Your Ref: OWPC23164
Our Ref: EP/47/19/HH 17-04-2019
Please ask for:
Zac Denton

Two storey side extension to include a double garage, single storey rear extension,
single storey front extension and altered vehicle access to property

11 Michel Grove East Preston

Block Plan
1: 500

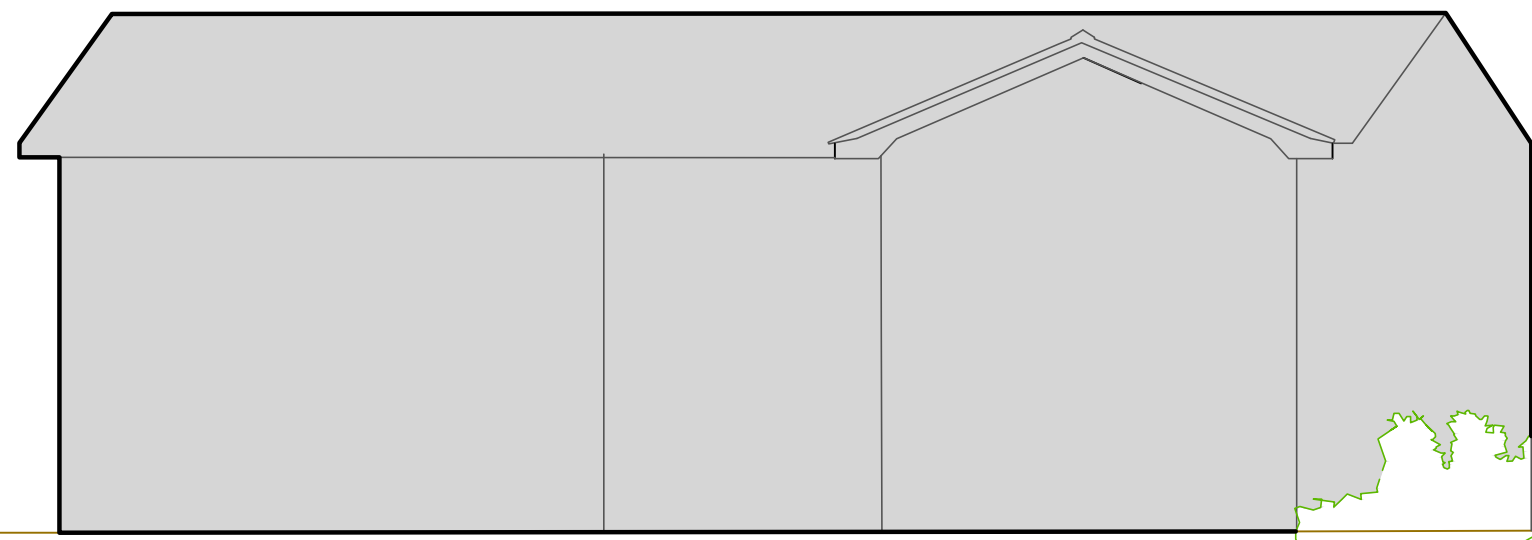
This revised proposal does not remove the features which led to the refusal of the previous application, EP/183/18. The main defect of that application was the size of the side extension, which came close to the western boundary of the site and virtually eliminated the gap between no. 11 and no.9. This gap is increased in size by 0.66metres in the present application. This minimal increase will not remove the undesirable effect of making the two houses appear to be one. This appearance would be incongruous in a road of detached houses.
